# CITY OF PORTLAND, MAINE

October 4, 2018

Project Name: **Conversion of existing school building into 8 residential units (Reed School Phase 2)**  
Project ID: Subdivision and Site Plan: # PLO00206-2018  
Address: 19 Libby Street, Portland CBL: 338 K004001  
Applicant: Reed School LLC  
Planner: Jean Fraser

# PLANNING BOARD REPORT PORTLAND, MAINE

Drawing file: Drawings / C1.1 SUBDIVISION RECORDING PLAT 1 OF 2.pdf

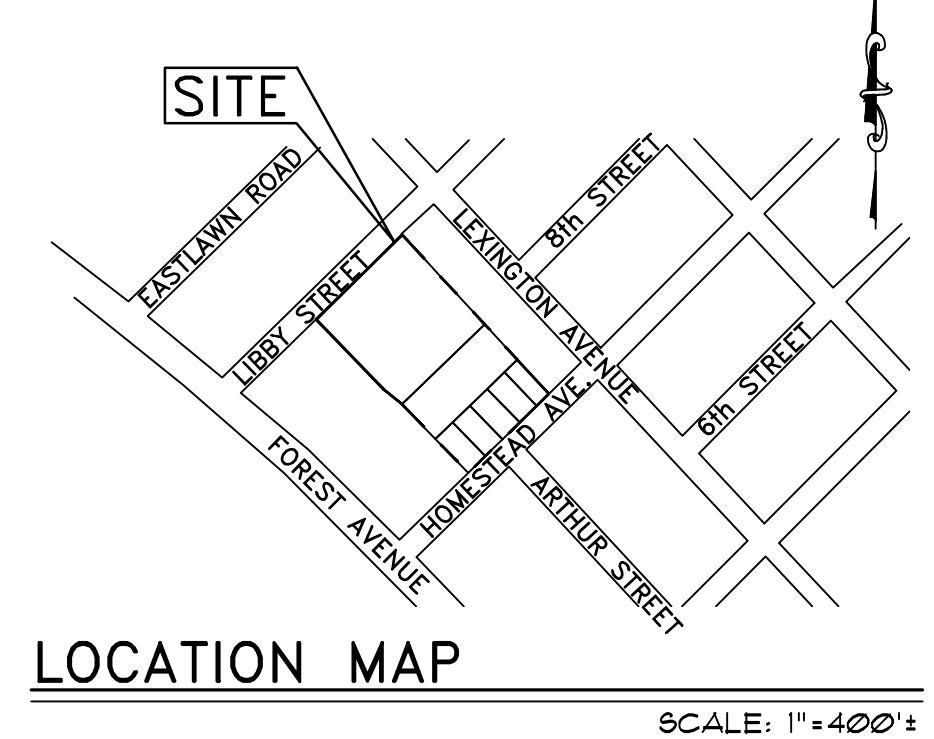
The applicant has submitted a draft Subdivision Plat ([Plan P3](#)) which will need revisions to add notes or a table to clarify the location and floorspace and legal status of all of the units, and to include references to the parking provision and condominium documents.

1. The applicant shall submit a final subdivision plat for review and approval by Corporation Counsel, the Department of Public Works, and the Planning Authority, that includes but is not limited to: clarification of the legal status, size and location of all units; parking provision to meet the zoning requirements; and reference to condominium documents and other agreements that clarify the maintenance responsibilities for snow clearing and landscape maintenance.
2. If some or all of the units are to be condominiums, the Condominium Association documents shall be submitted for review and approval by Corporation Counsel and Planning Authority and clarify rights and responsibilities for access, use and maintenance including snow storage and snow clearance from the sidewalks.

C2.1

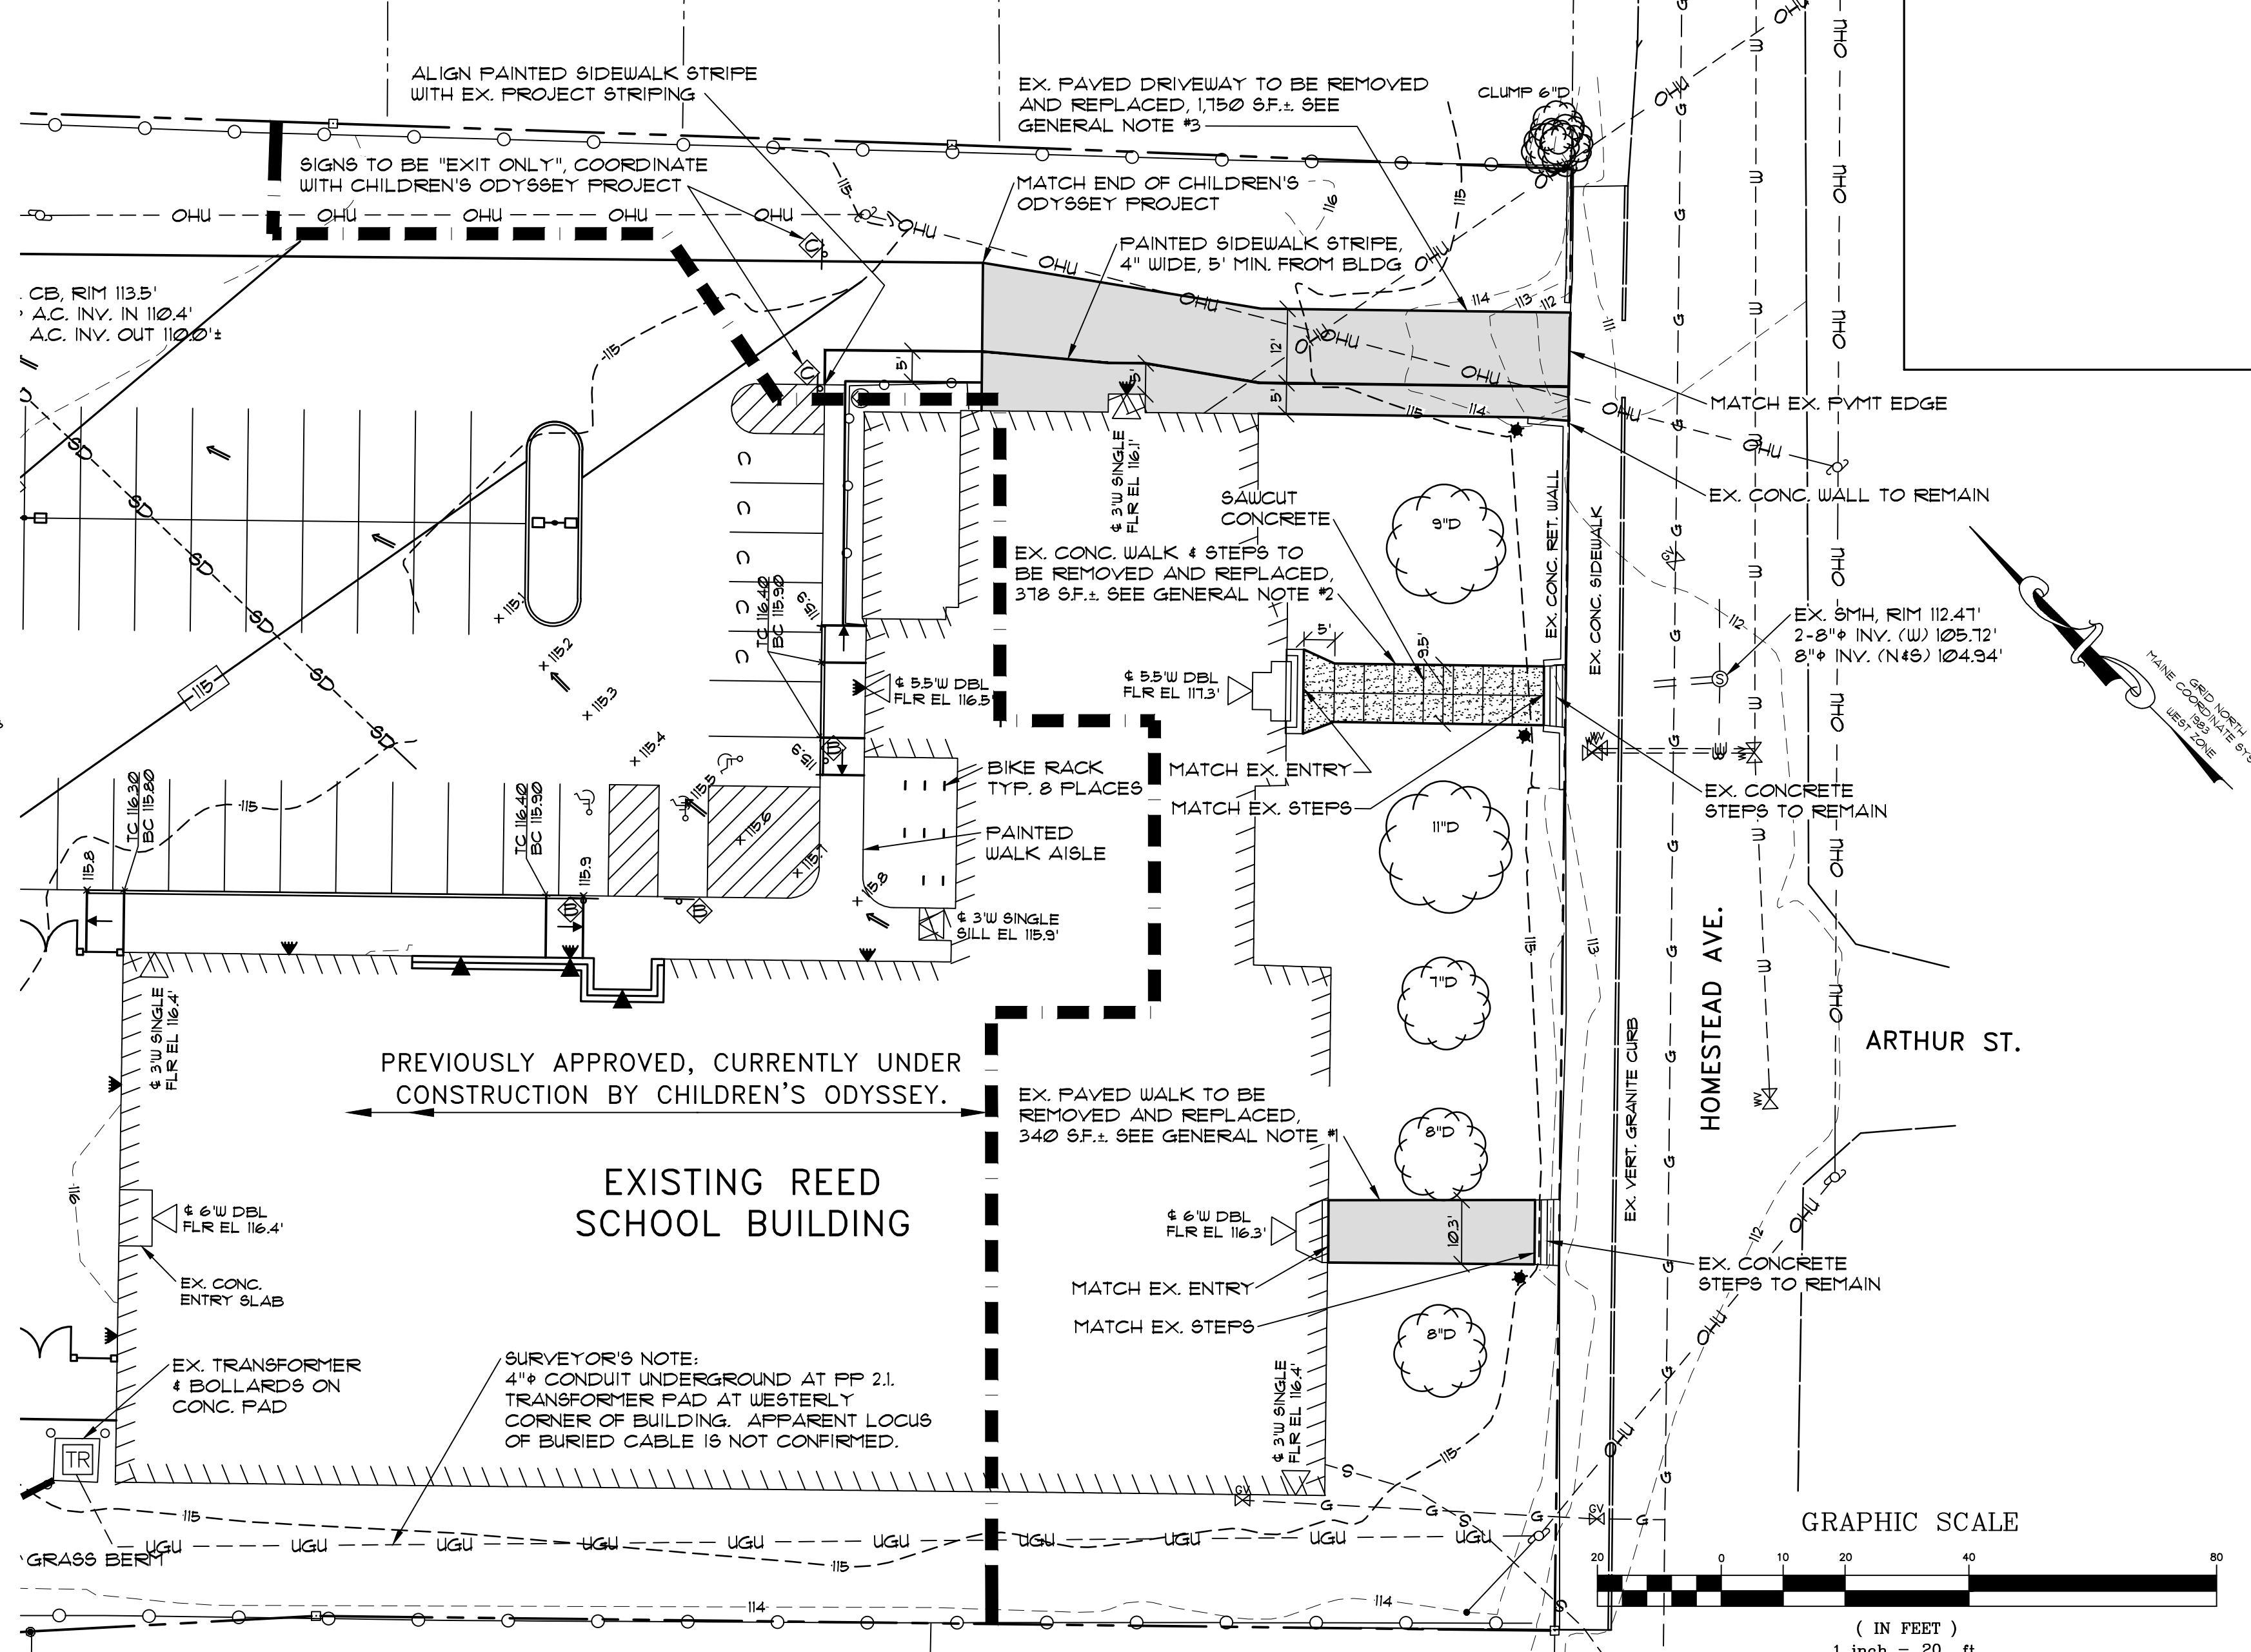
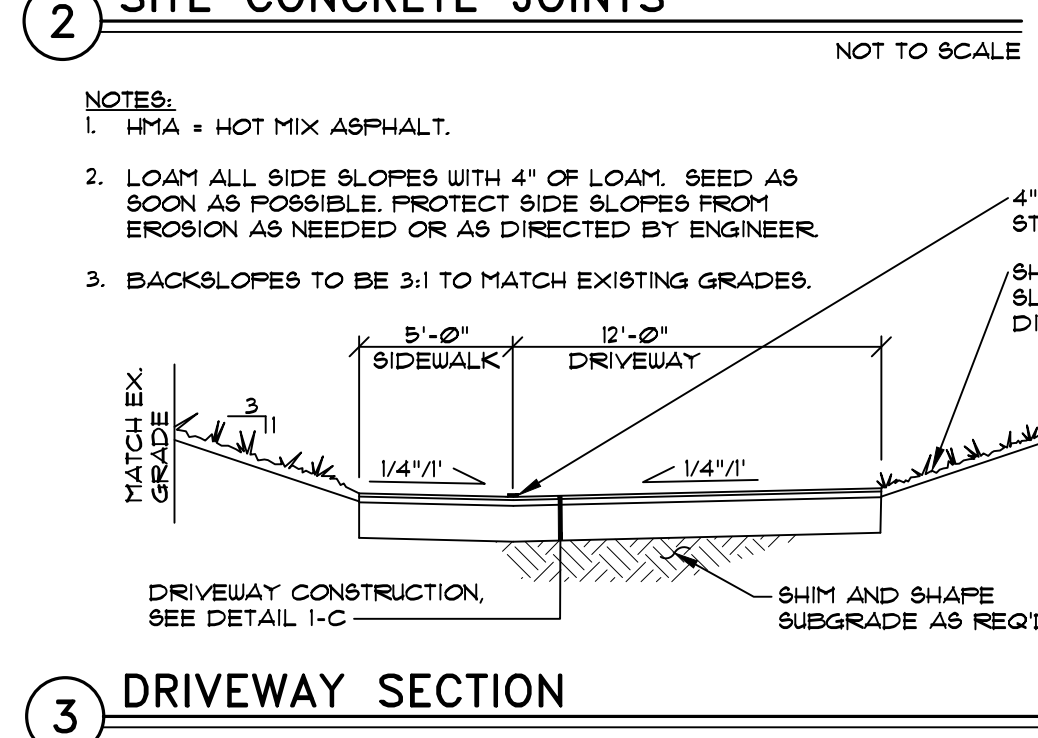
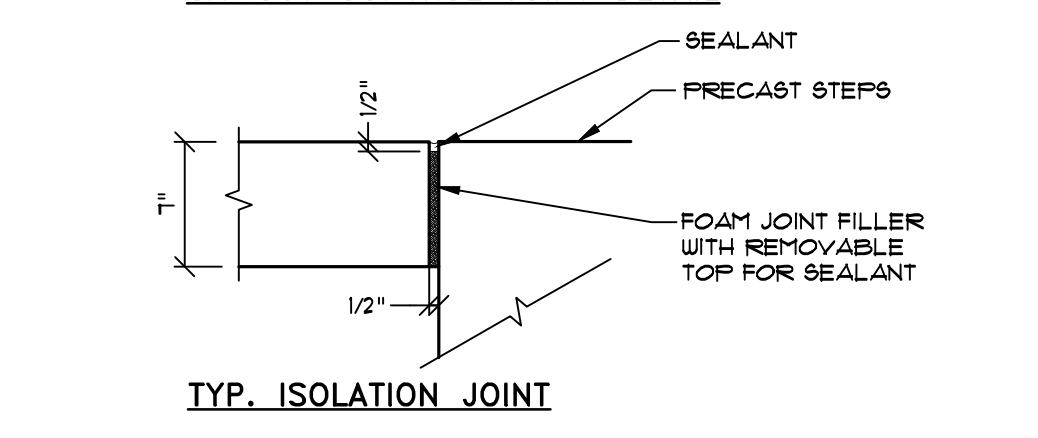
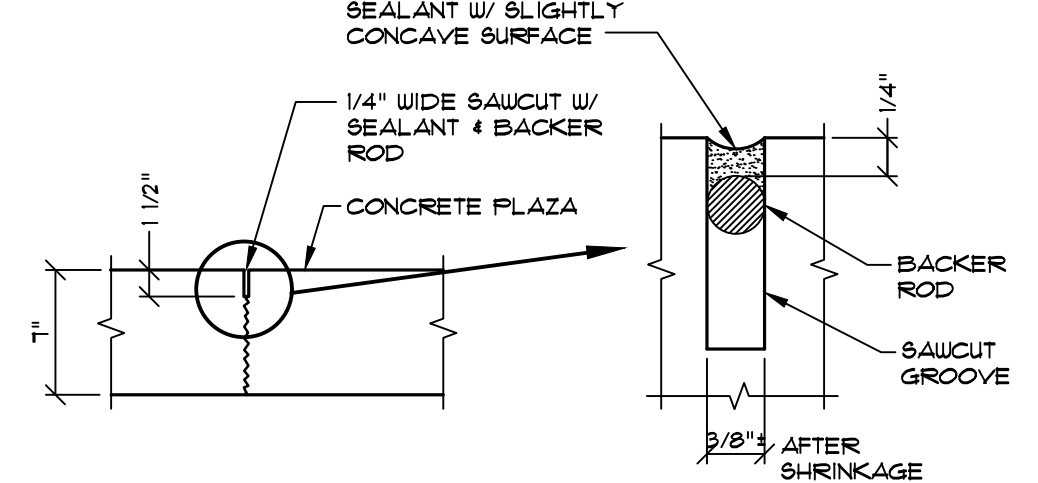
The site plan (Plan P4) shows “no entry” signs where it meets Homestead Avenue to reinforce that circulation, and a 4 foot wide pedestrian walkway striped at the side. In view of the one-way nature of the driveway, staff consider

the proposal meets the condition and is acceptable.
